Comments for Planning Application 1/0753/2021/FUL

Address: Great Knowle Barn Pyworthy Holsworthy Devon EX22 6JY

Proposal: Creation of attached single-storey annexe, change of cladding to approved barn conversion and increase of domestic curtilage

DRAWING TITLE  
PROPOSED ANNEXE + ALTERATIONS  
Elevations

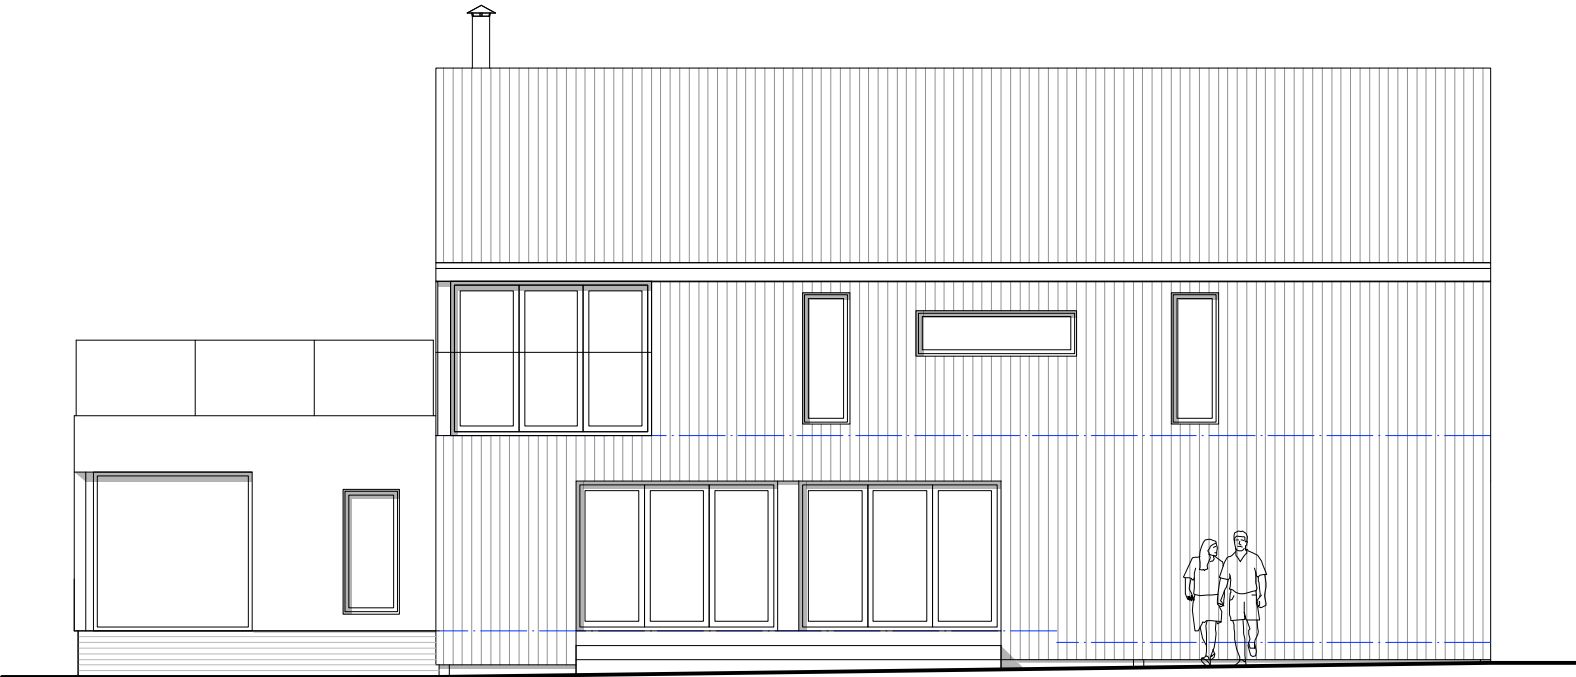
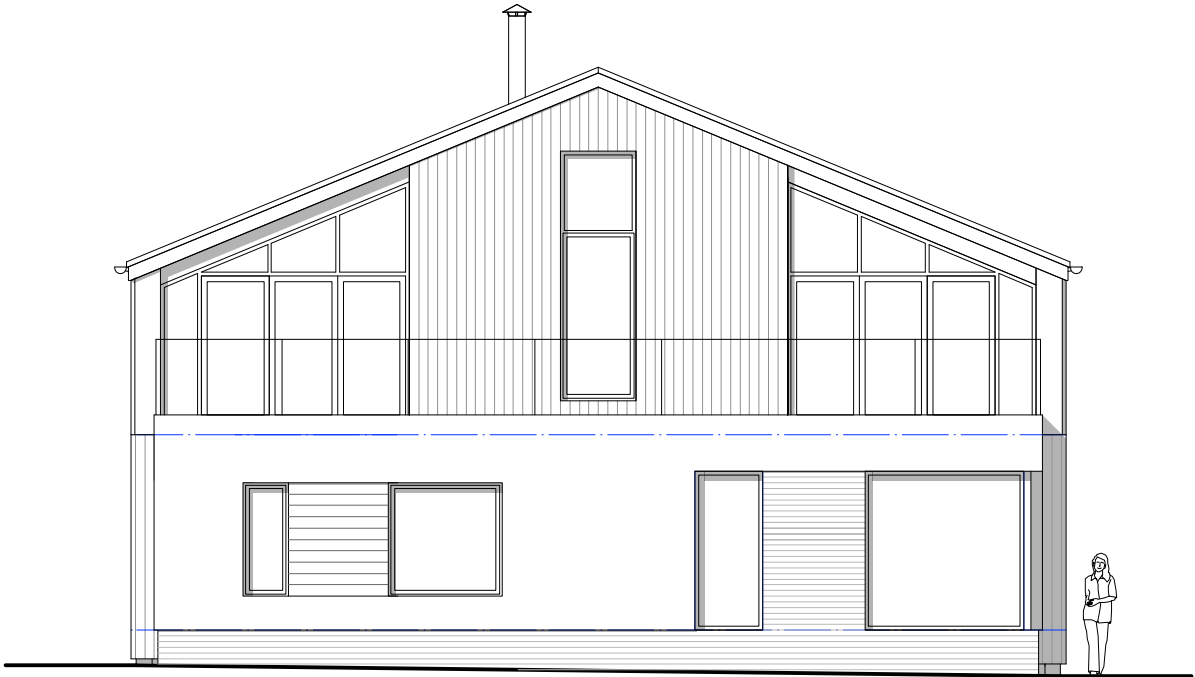
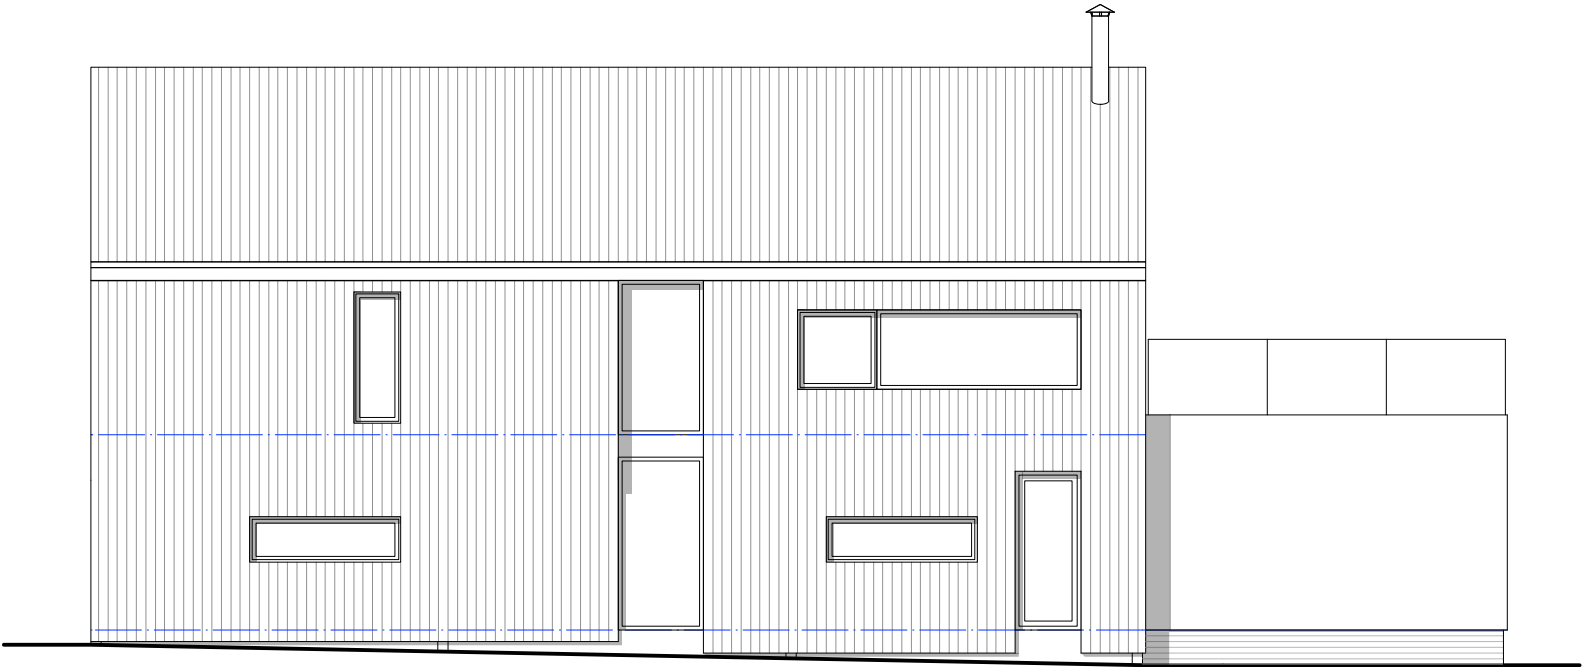
Our objection to this application is due to being overlooked from the proposed balcony. In the covering letter with this application it states that the only issue that may arise is the overlooking of the property to the South. This letter also states that my property is screened from the proposed balcony by a number of existing outbuildings. This is totally wrong as from the front bedroom and kitchen windows we have full view of the East and South elevations of the proposed balcony and the East and South elevation of the approved dwelling. From the proposed first floor balcony you will have clear view of my kitchen and bedroom windows which i feel is an invasion of our privacy. If the applicant is given permission for this development then i urge TDC planning Committee to place conditions on this for screening to the South and a tree preservation order on all trees on the South hedge bank. As i understand the current AGMB/Q rules once permission is granted under these rules no increase in the footprint granted is allowed. Pyworthy Parish Council has opposed this application in the strongest of terms, i am a member of this council. Our Torridge District Councillor Mr Ken James has assured me that he has called this application in to full planning committee.
